FW: P/5/26/PL

I'm just about to head on site and post the notices for this application, but in reviewing the description and given the size of the rear dormer proposed to the existing bungalow, I think it is worth including a specific reference to the inclusion of the dormer extension within the description and on the notices to be posted.

'1 No 4-bed chalet bungalow, alteration of existing bungalow to include off-street parking and rear dormer extension (resubmission following P/118/25/PL). This application is in CIL Zone 4 and is CIL Liable as a new dwelling.'

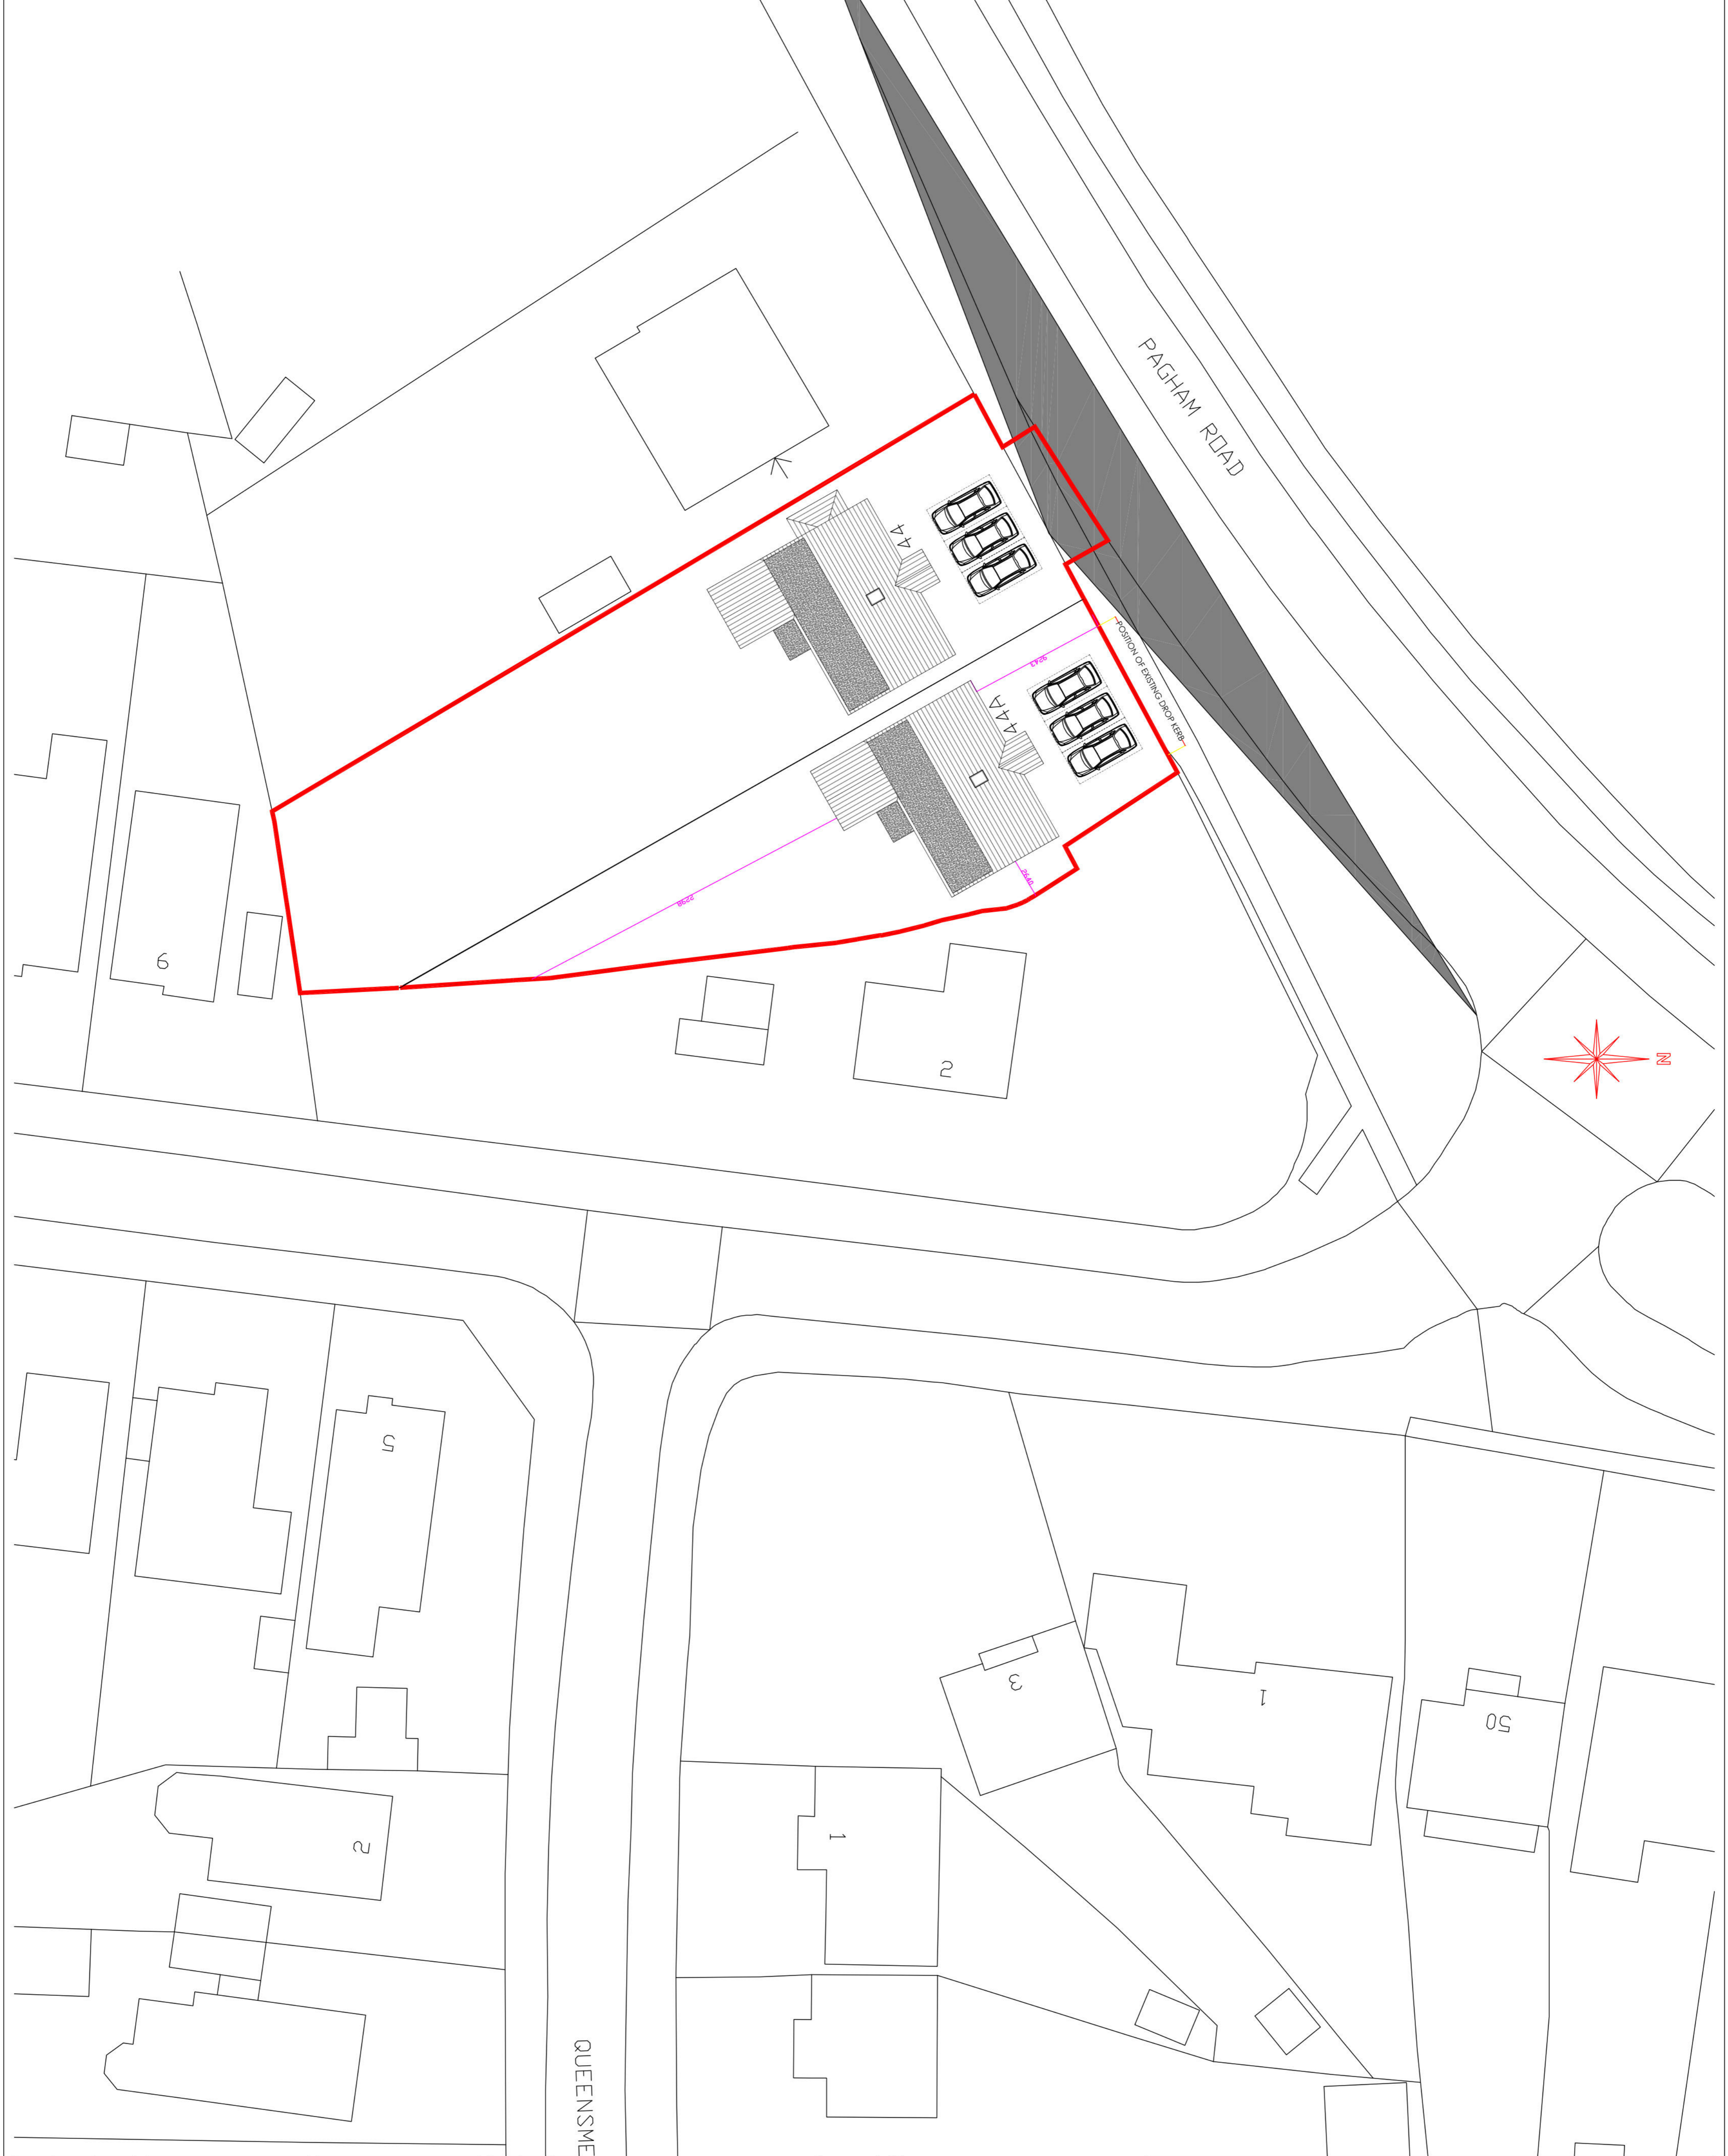
Could I request an amended Block/Site Plan that accounts for the amendments to the rear dormers? The roof areas on the current plan does not reflect the reductions made. In noticing this I also spotted the chimney of the existing dwelling is absent, please also ensure this is visible.
